18039-01-002

**Proposed Residential Development
at Lands at Capdoo & Abbeylands,
Clane, Co. Kildare**

ROAD SAFETY AUDIT STAGE 1 / 2

October 2019

TYPICAL LAYOUT OF DISHED KERB DETAIL WITH USE OF TACTILE PAVING SURFACES FOR PEDESTRIAN ROAD JUNCTIONS THROUGHOUT DEVELOPMENT SCHEME. scale 1:50

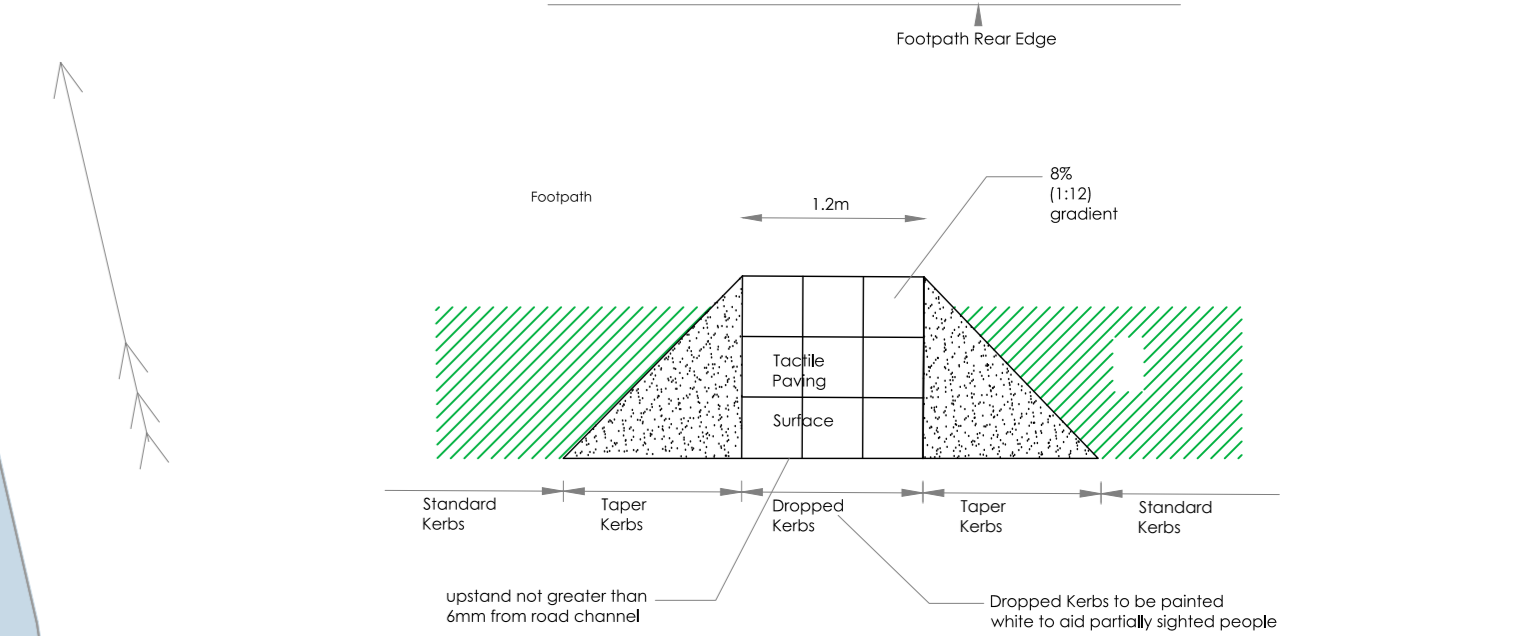
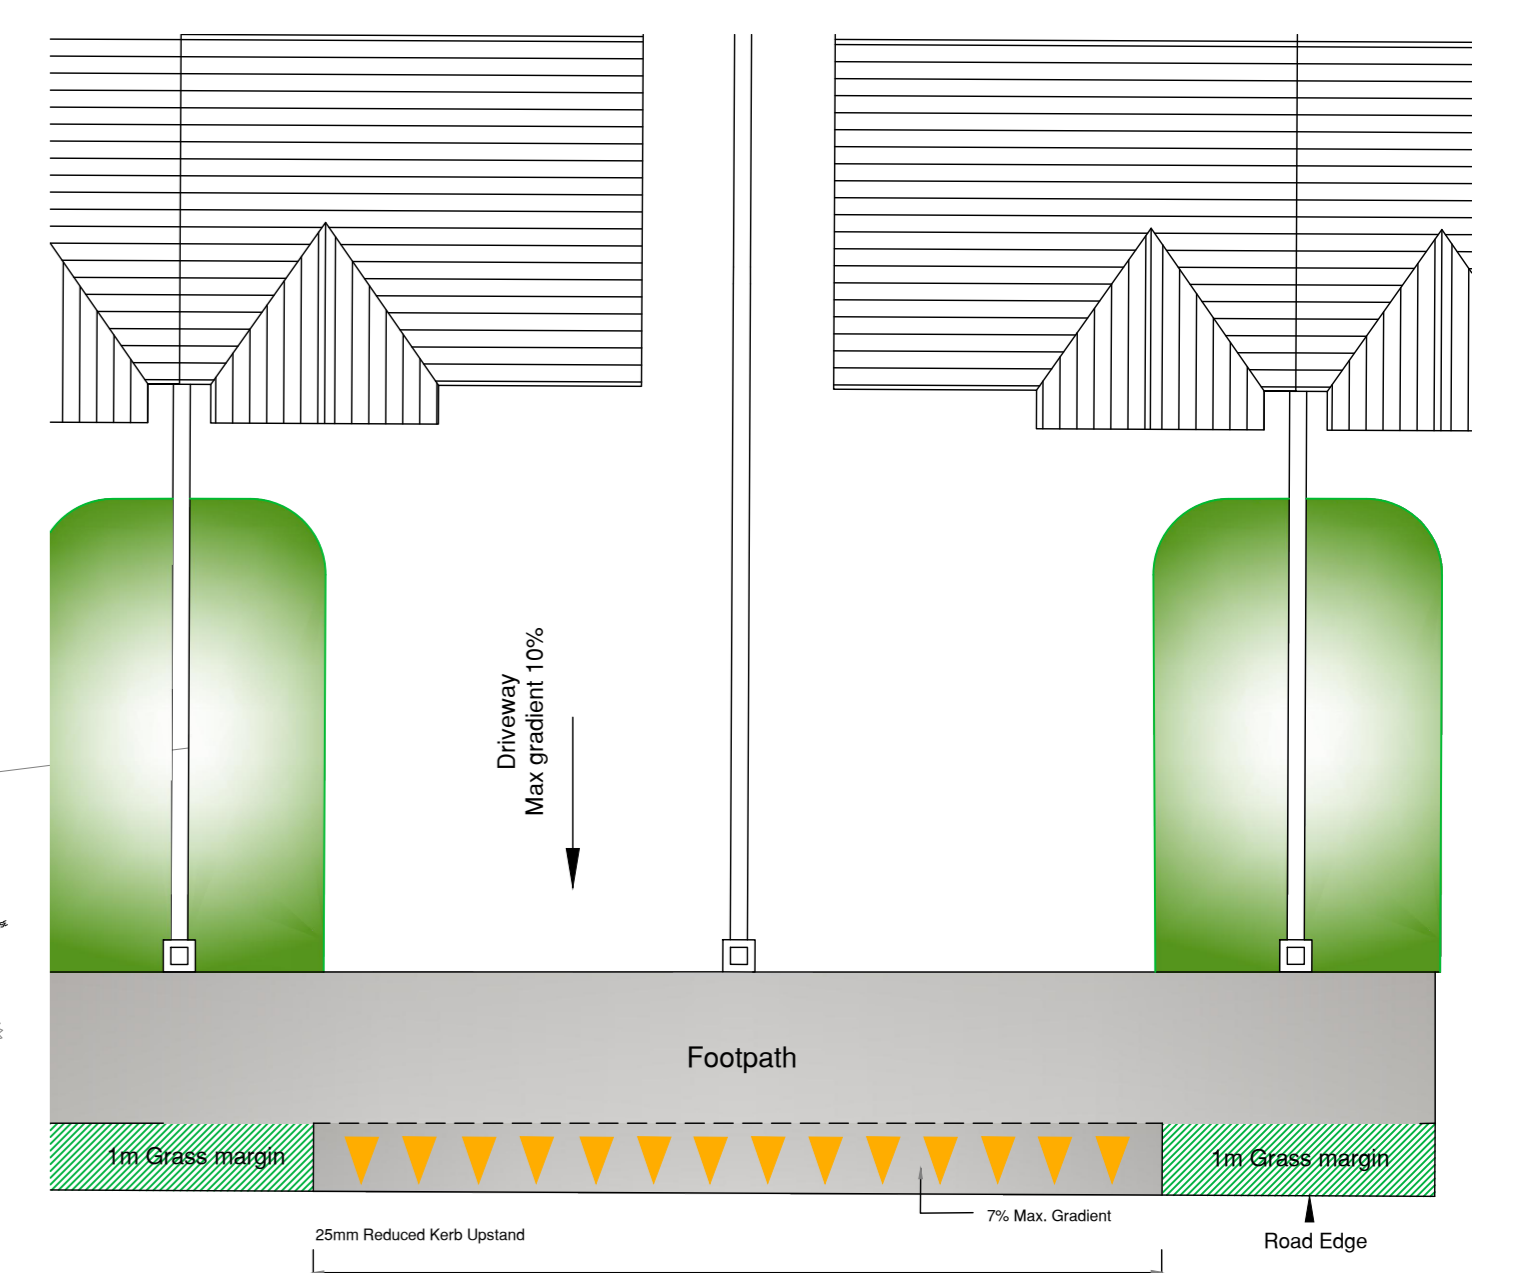
Adequate pedestrian crossing facilities are not shown to be provided at pedestrian crossing locations within the proposed development. This may result in an increase in pedestrians being struck by a passing vehicle due to inadequate crossing facilities at pedestrian crossing locations.

Provide adequate pedestrian facilities such as dropped kerbs and tactile paving at all crossing points to cater for the pedestrian desired lines within the proposed development.

Drawing file: Engineering / 18002 308 SHD KDA1 Site Layout - Swept Path Analysis 191109 BC.pdf

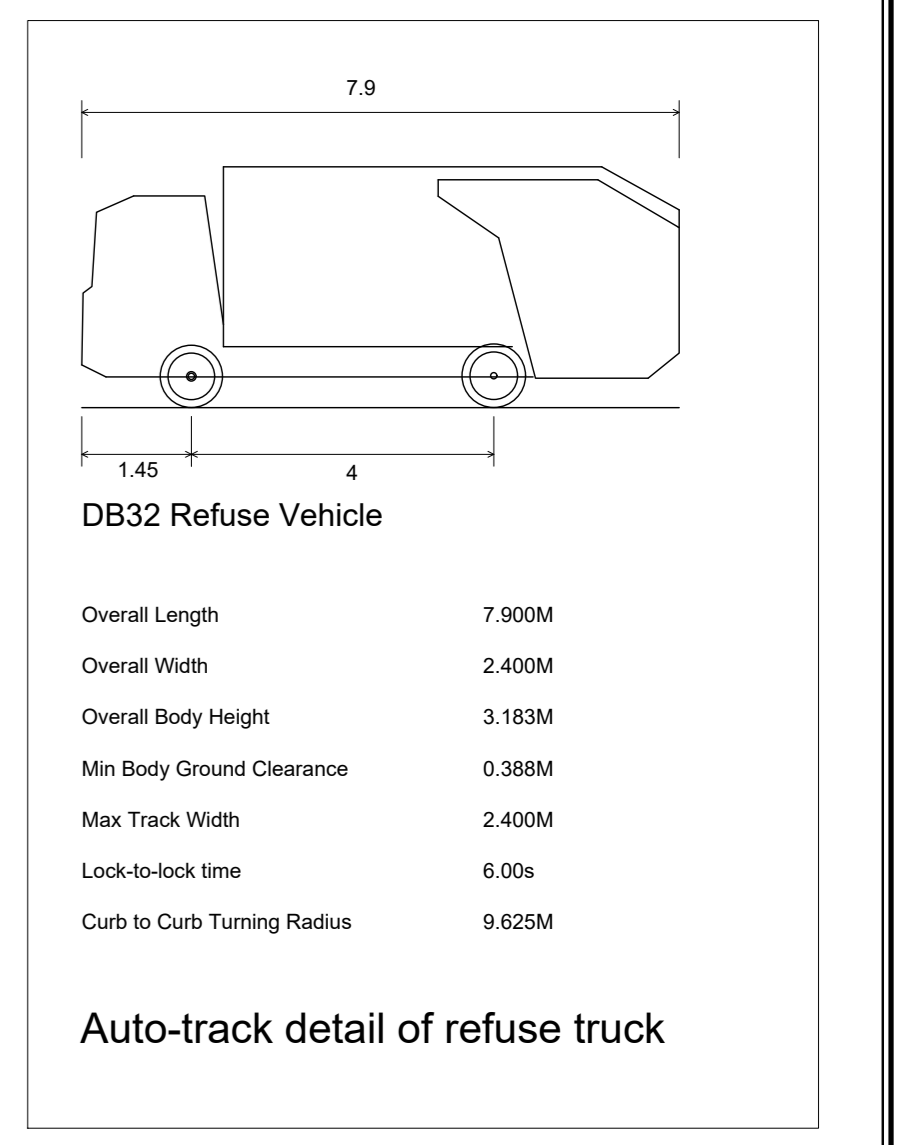
There is no adequate footpath link provided to cater for pedestrians accessing apartment block B from the proposed car parking facilities.

Low radius bends are proposed on the access road to apartment blocks A – C adjacent to parking bay 20 and parking bay 49. Two vehicles may have difficulty in passing one another on these bends which may lead to a side swipe collision. Stopping sight distance at the bends may also be restricted by the proposed parking on the inside of the bends.

Road markings and signage are not shown to be provided at the proposed residential access onto Brooklands, the proposed crèche access onto Brooklands and all the internal junctions. This may lead to collisions at the junctions as priority at the junctions may be unclear.

A low radius bend is proposed along the access road connecting to Alexandra Walk. Two vehicles may have difficulty in passing one another on this bend which may lead to a side swipe collision.

Provide an adequate footpath link to cater for pedestrian accessing apartment block B from the proposed car park.

Revise the layout at the bends to ensure that two vehicles can safely pass one another and that adequate stopping sight distance is provided.

Provide adequate junction control to clearly define vehicular priority at all junctions.

Revise the layout at the bend to ensure that two vehicles can safely pass one another.
